Sent: 31 October 2018 11:01
To: Stuart Corbey
Subject: RE: BR/198/18/HH & BR/216/18/L - Milford Cottage

The proposal is for the demolition of an existing outbuilding, and the erection of a two storey extension.

Milford Cottage is attached to the Grade II listed building, 10 The Steyne, and therefore is itself a listed structure. Originally a single building with slate roof and rendered walls, the house in question is now in separate ownership, and forms a small house which is accessed from Market

Scale 1:50		Applicant: Angela Taylor Address: Milford Cottage Bognor Regis PO21 1TD	
Project: Two-storey extension		Revision date: PLA002	
Scale: 1:50 @ A1		Date: 11/07/2018	
Title: Proposed floor plan and elevations		Plan No: PLA002

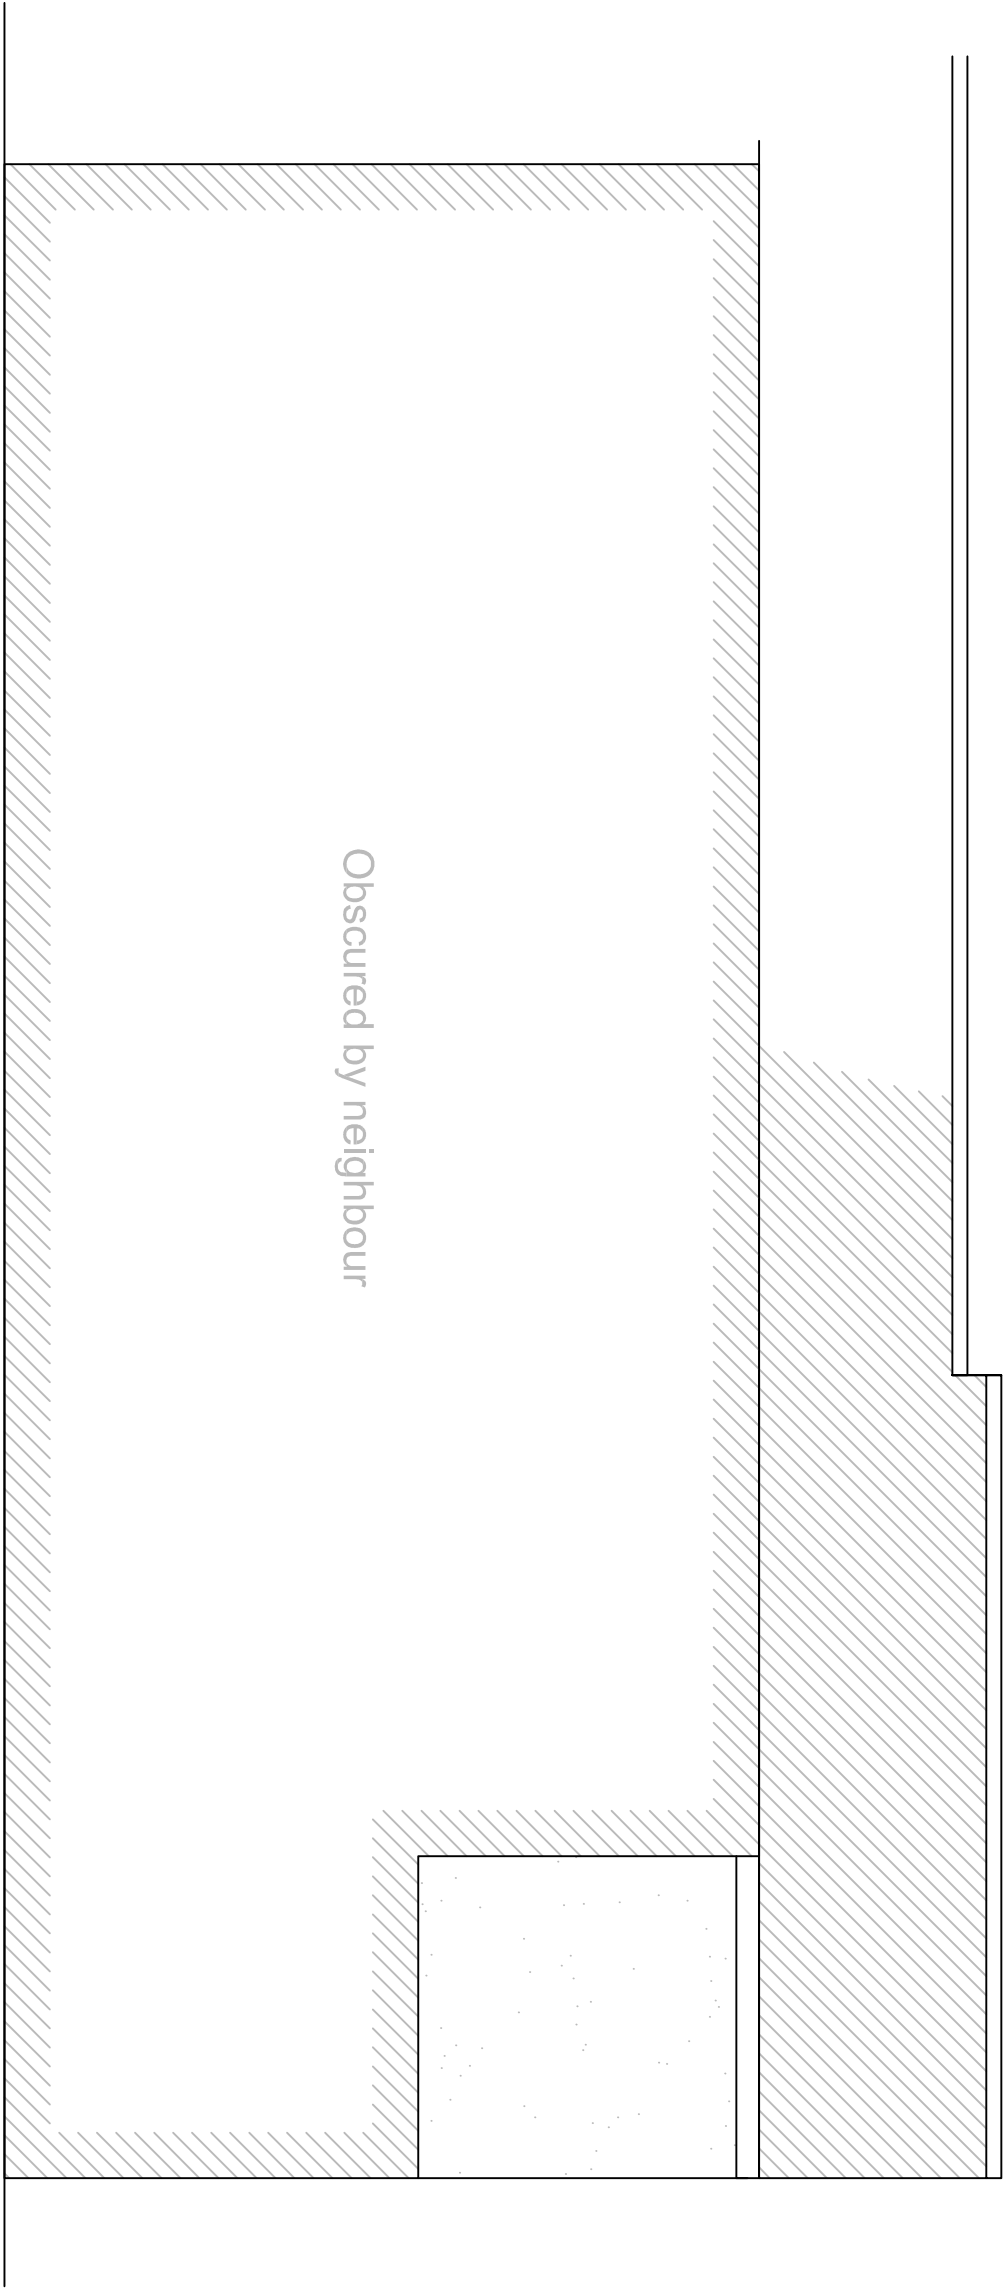
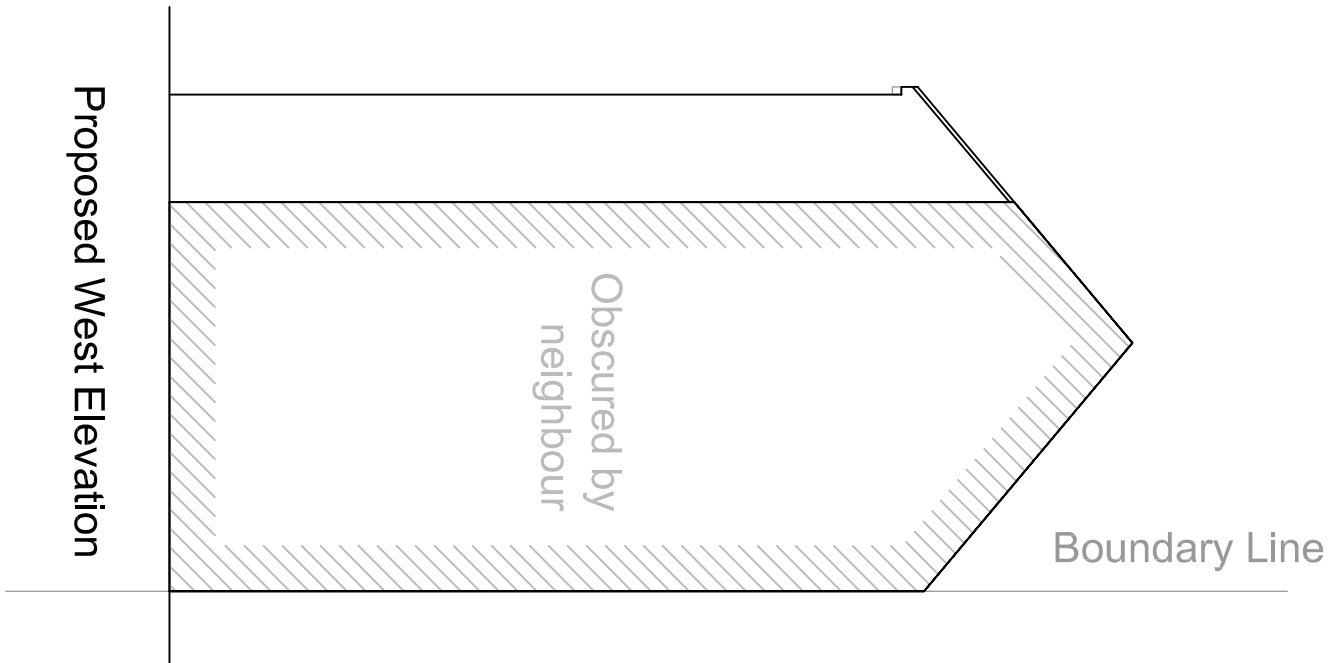
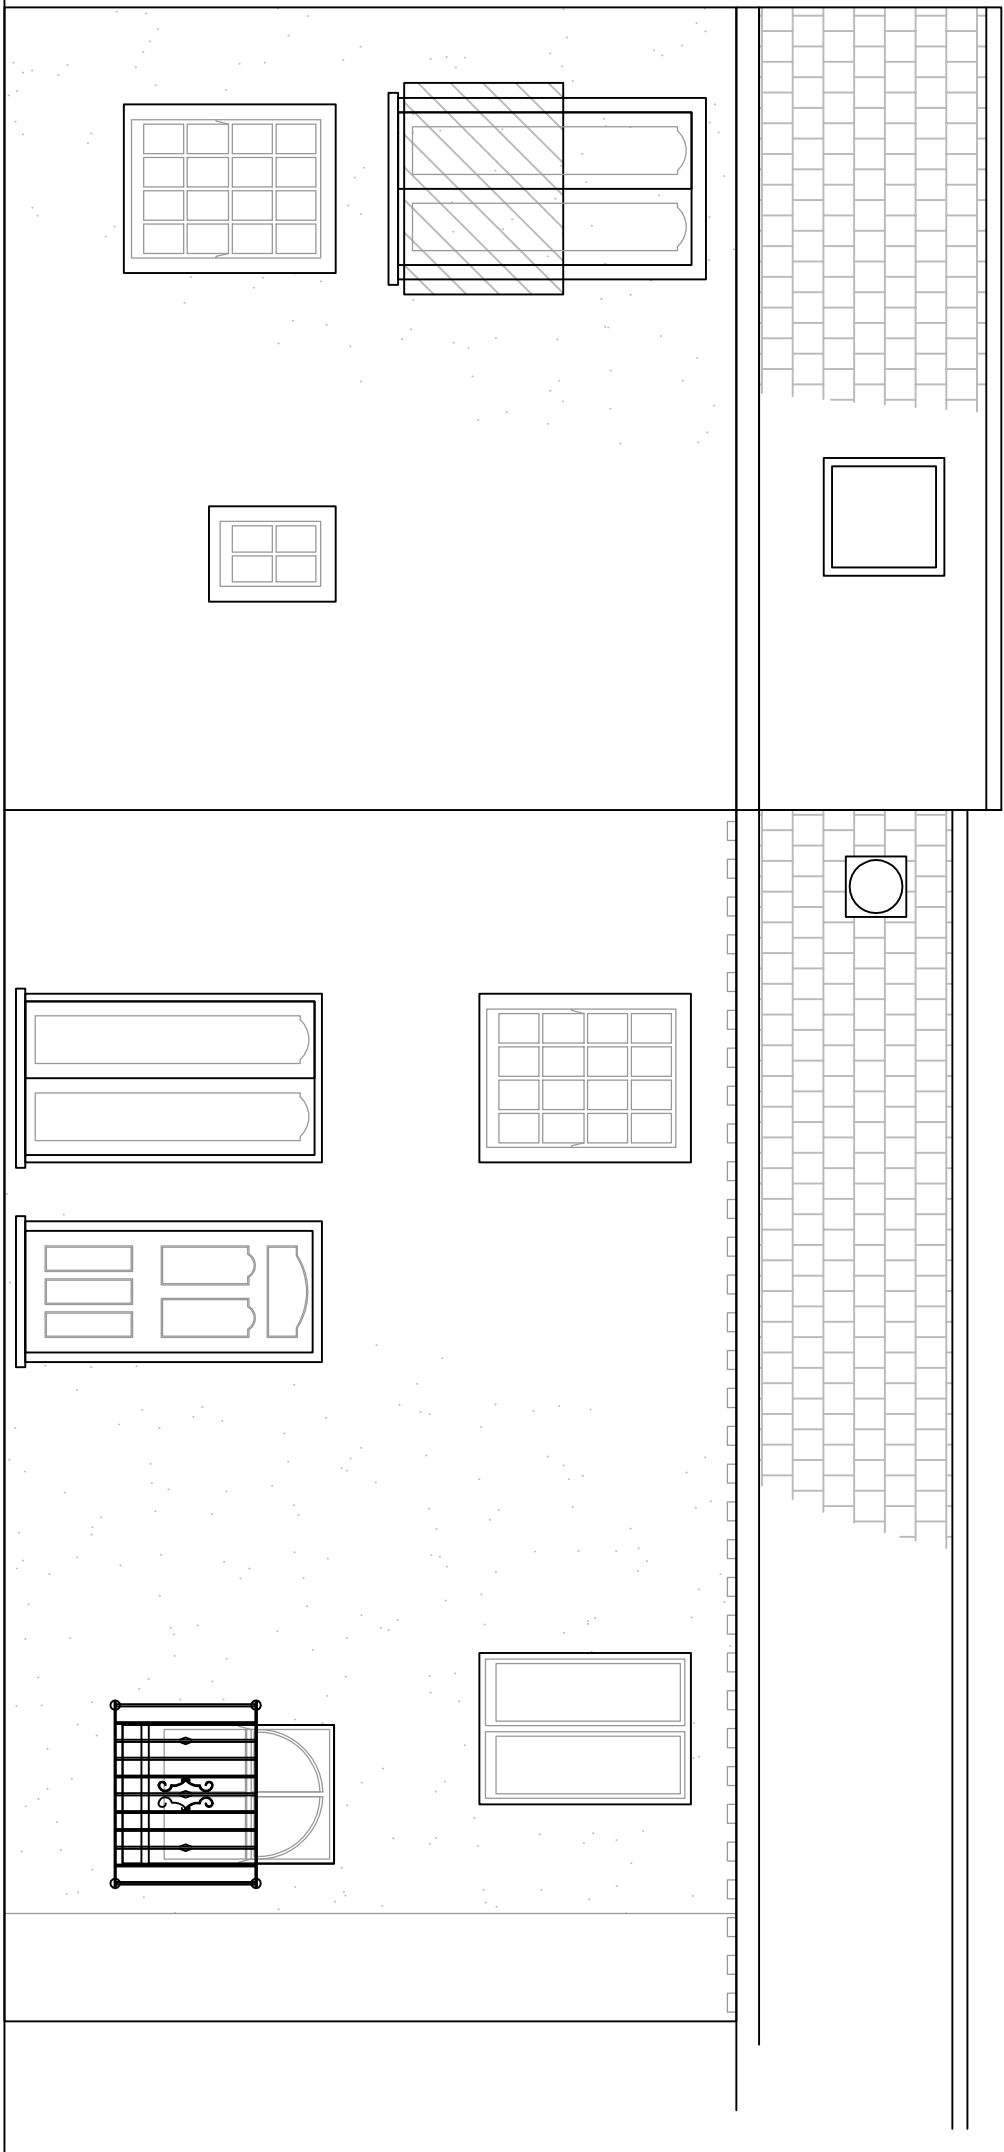
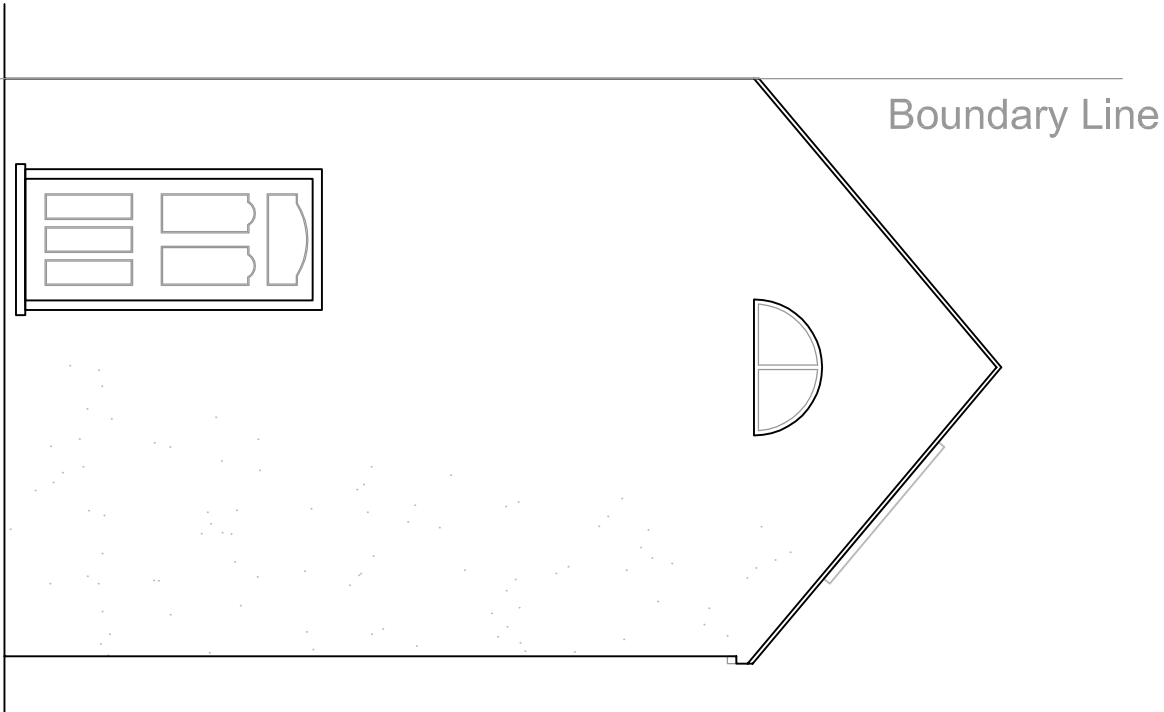
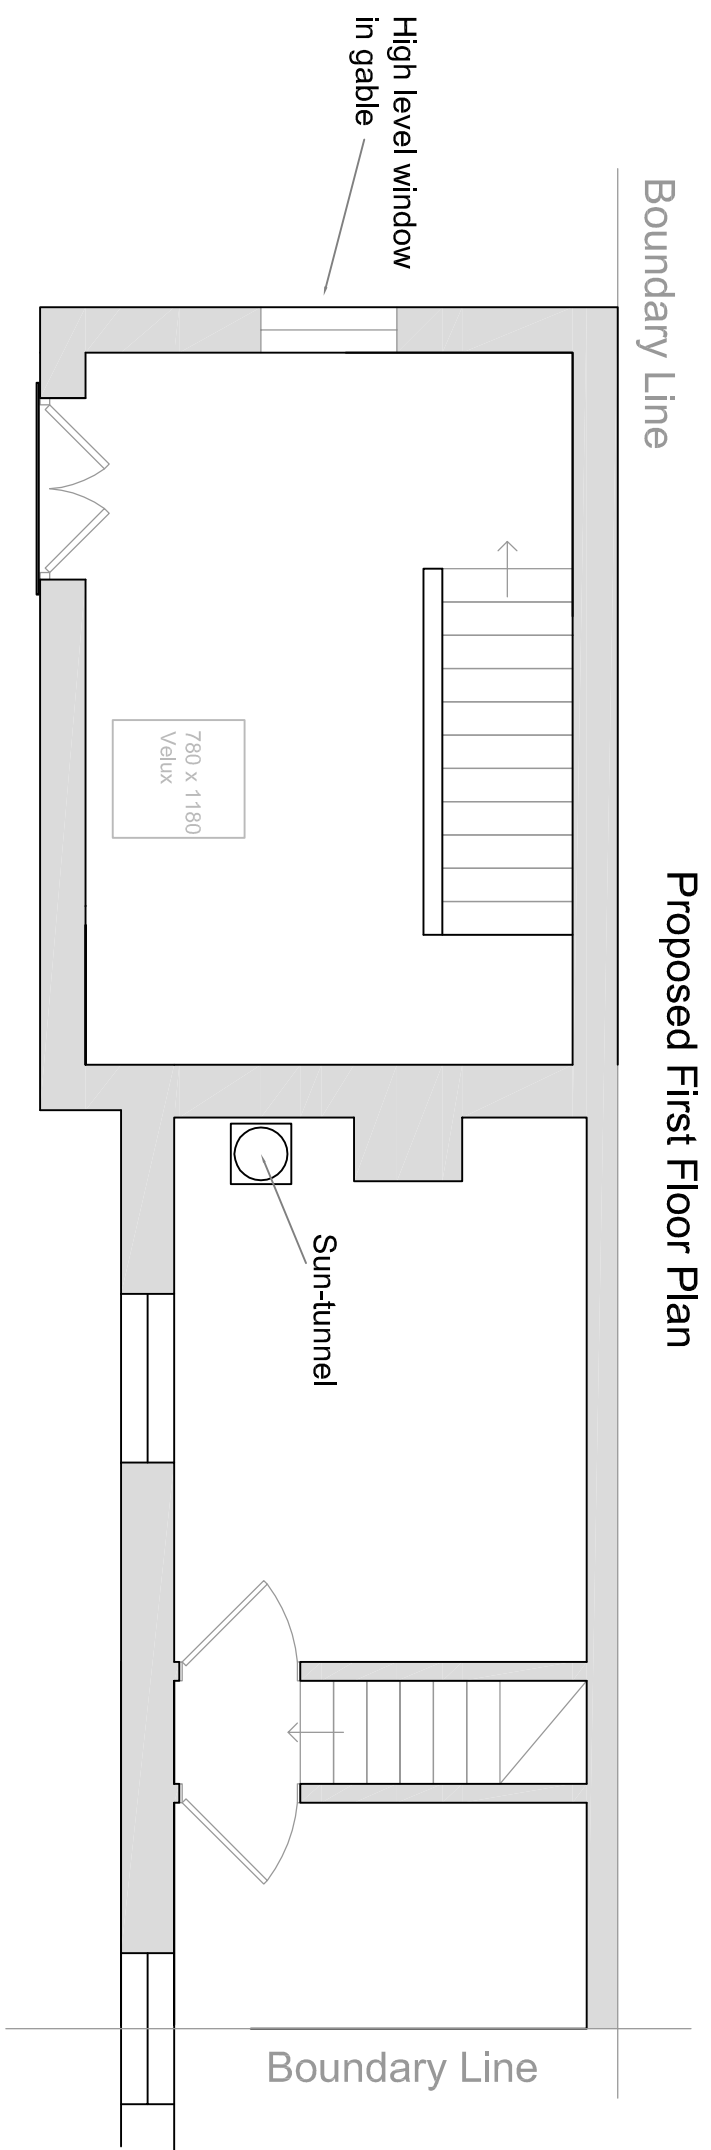
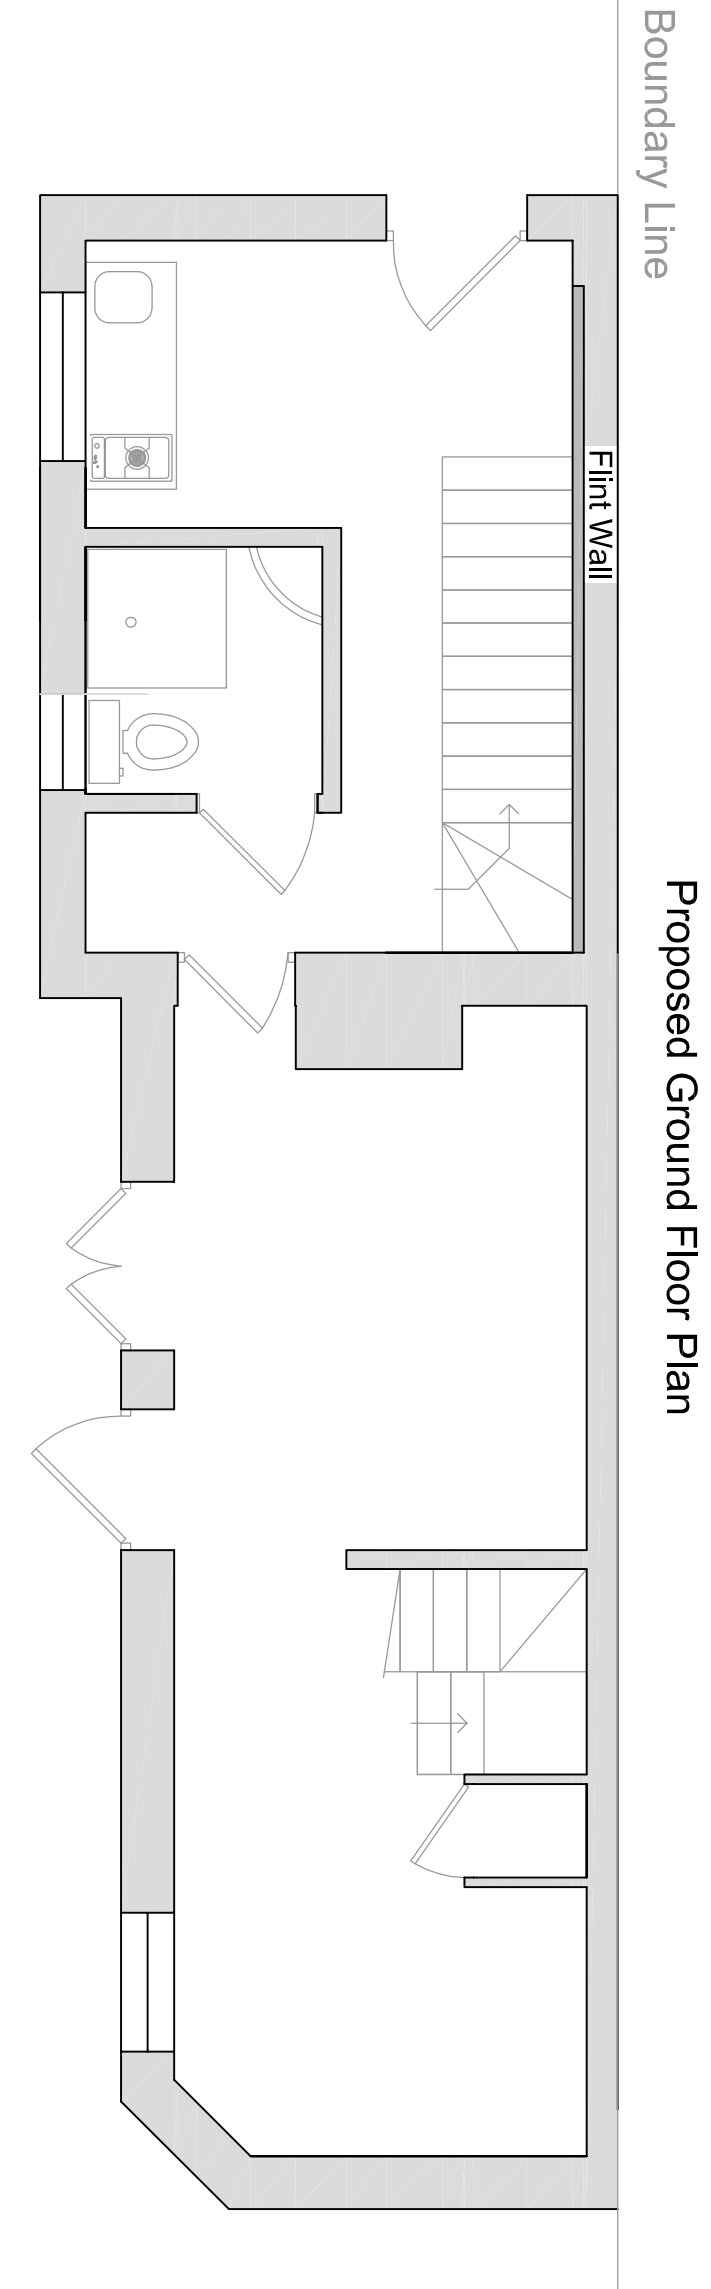
The proposed two storey extension, on the other hand, is considered problematic and cannot be supported in its current form. The extension is considered to be substantial in nature and is wider than the host dwelling. It therefore cannot be considered to be subservient to the host dwelling.

In addition, it seems to accommodate a significant amount of the curtilage with very limited uses; a bedroom, shower room and a large area of hallway/corridor space.

Looking at the proposed elevations, it looks as if the proposal results in the loss of an original/older sash windows. Such a proposal cannot be supported. The use of French windows complicates the elevation and is in contrast with the simple nature of the building. The proposed east elevation contains a single door and small first floor window which does not make a positive impact upon the street-scene.
